PLAN REVIEW SHEET

Petition #: RZP 2021-096

Address: 719 E. 36th Street

Request: MUDD-O

SHEET TITLE: TECHNICAL DATA
 SHEET NUMBER: RZ-1

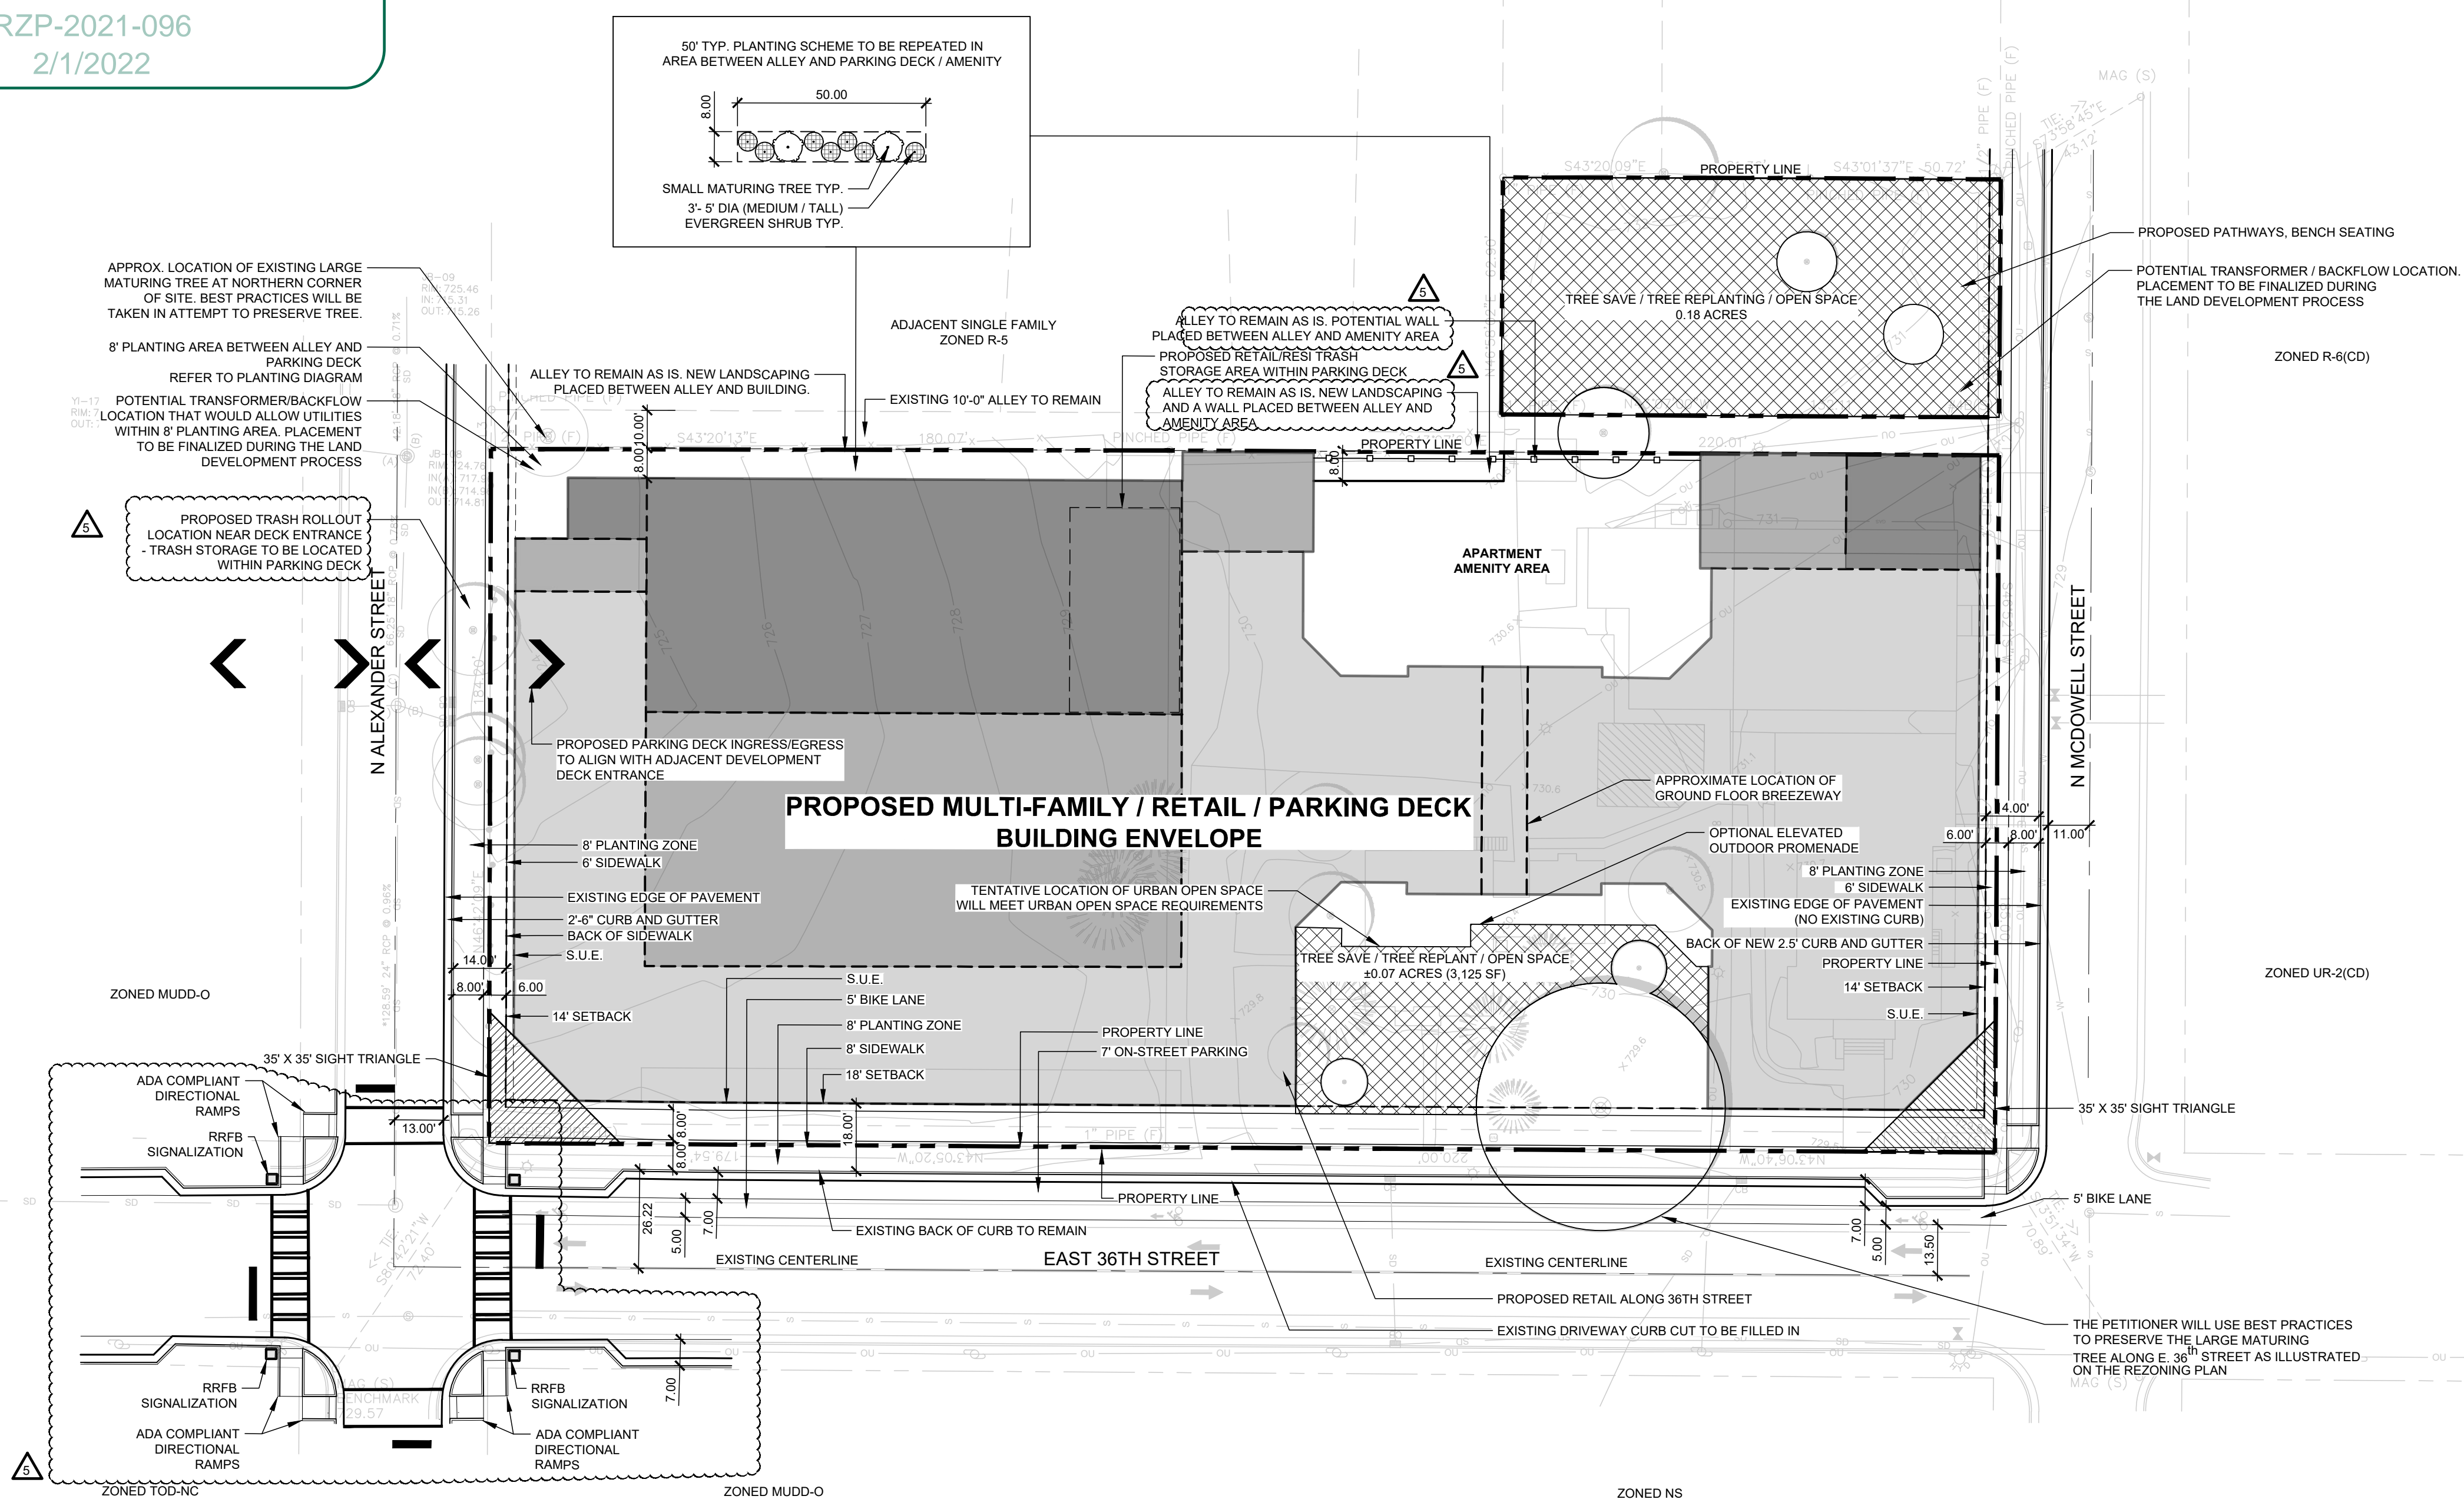
The site is located along CATS local bus routes #3 and #23 along East 36th St. CATS requests the construction of an ADA compliant bus pad per Land Development Standard 60.01B in the area of the existing stop. The final location of the pads will be coordinated with the developer through the permitting process.
